Current Zoning: UMUD(O) (Uptown Mixed-Use District, optional).
Proposed Zoning: UMUD(O) SPA (Uptown Mixed-Use District, optional, site plan amendment).

Approximately 0.42 acres located on the east corner of East 8th Street and North College Street, and west of East 9th Street.

The petition proposes a site plan amendment to petition 2010-065 to eliminate off-street parking requirements. The site is currently developed with a hotel.

Planning Department

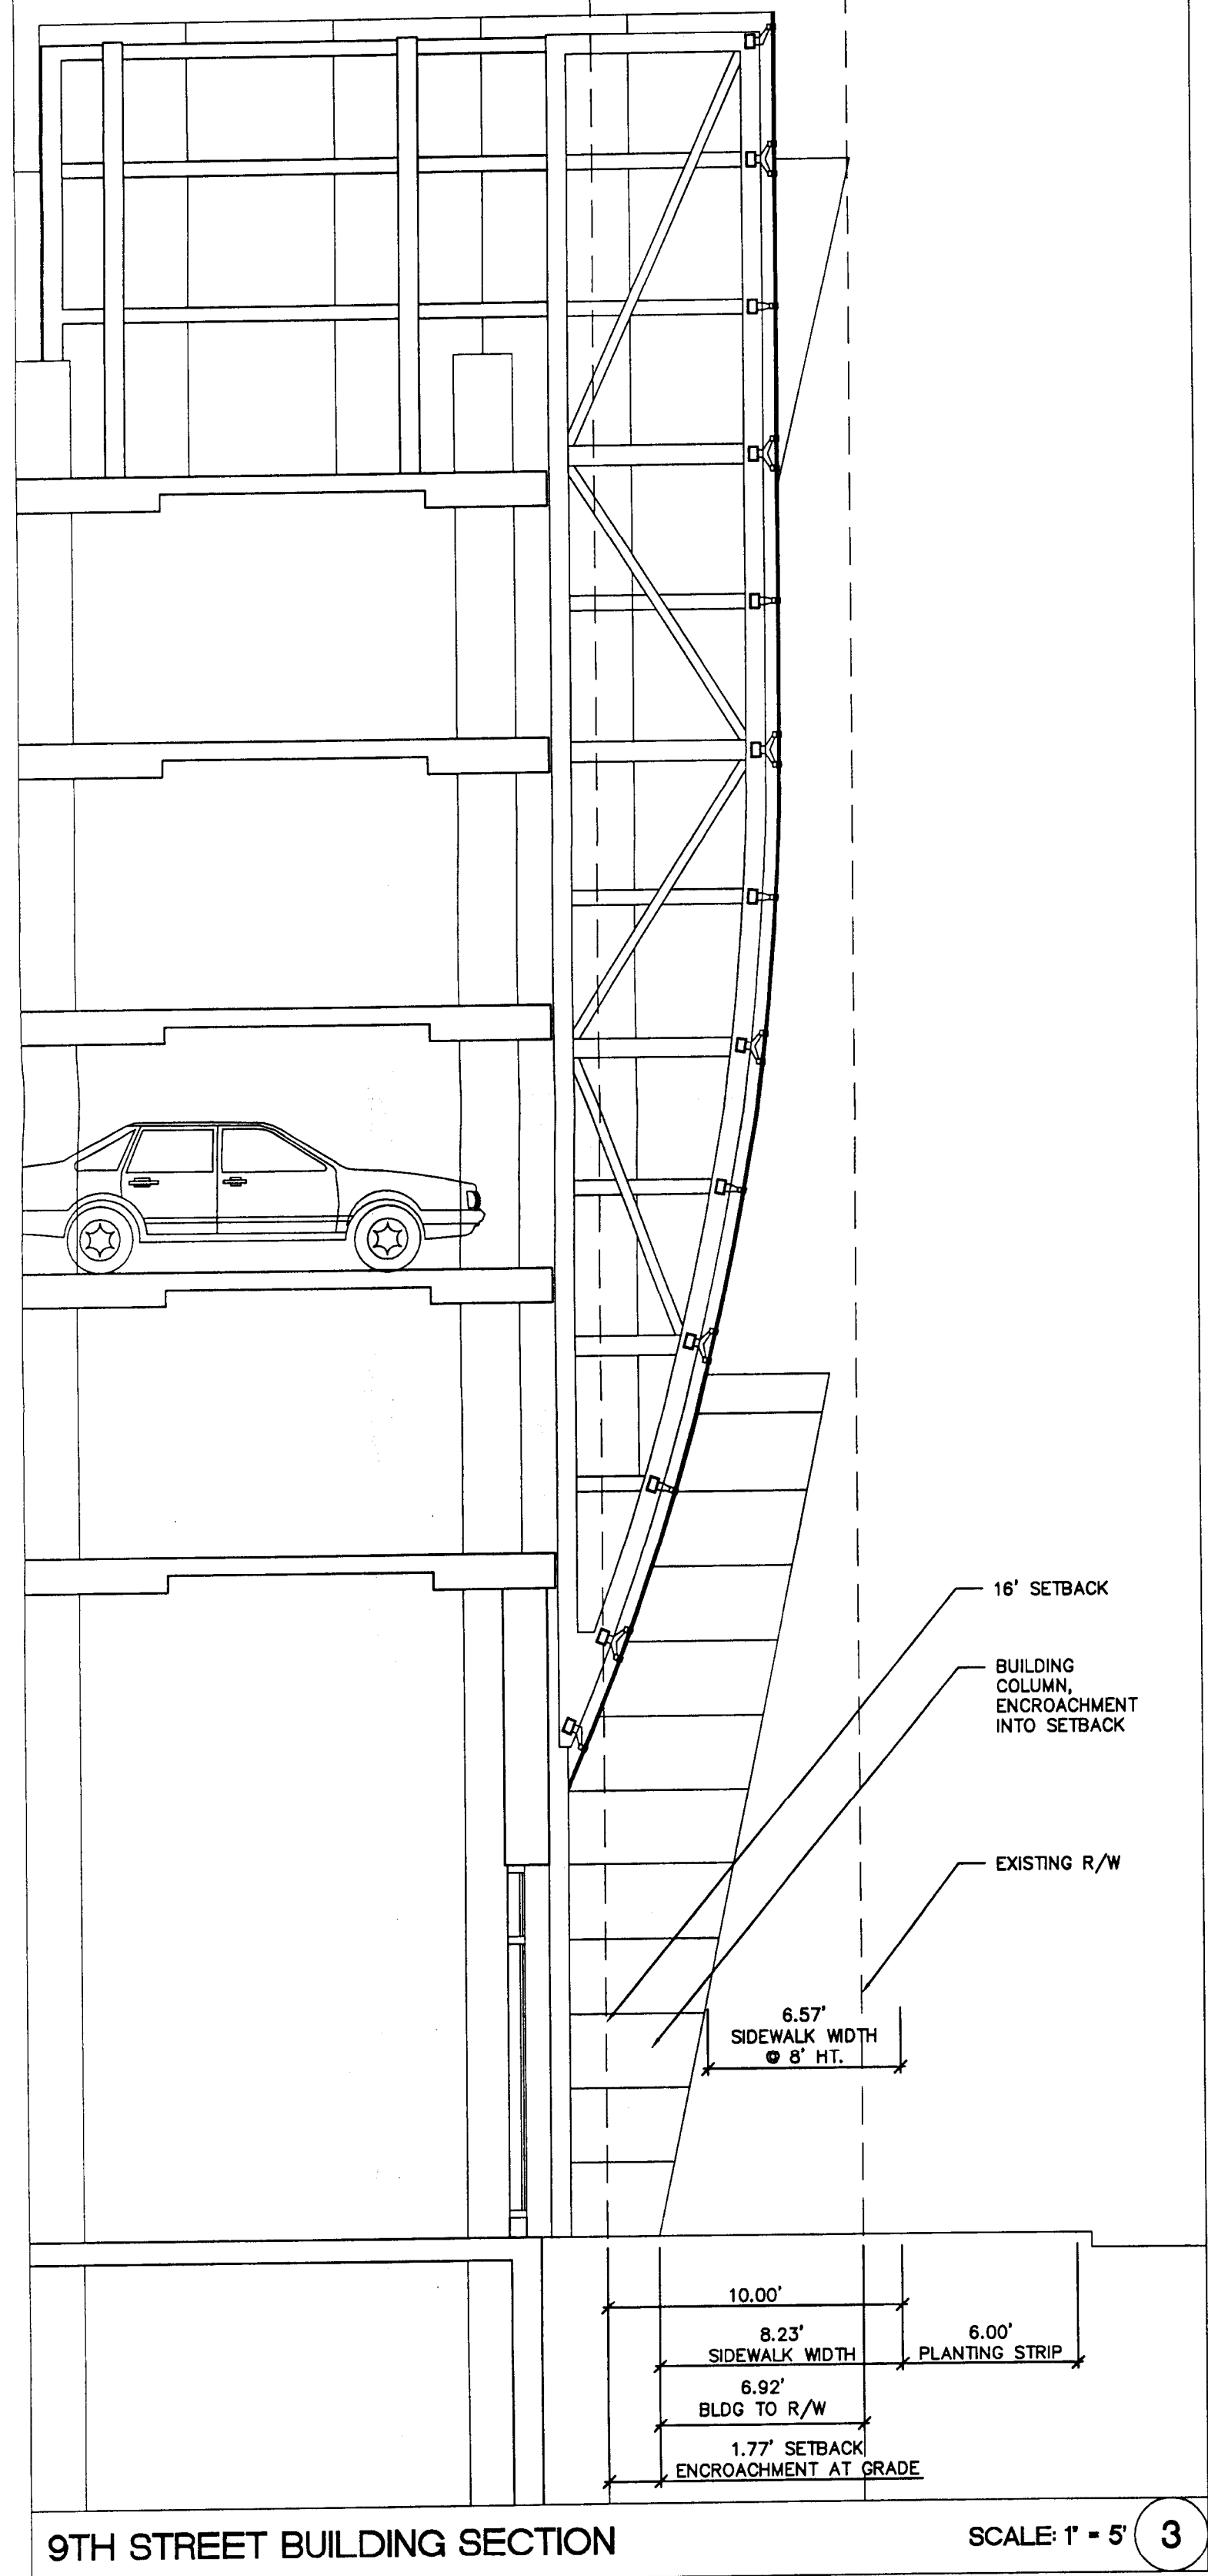
1. ~~Entitlement Services: Add rezoning petition number to site plan.~~ Addressed
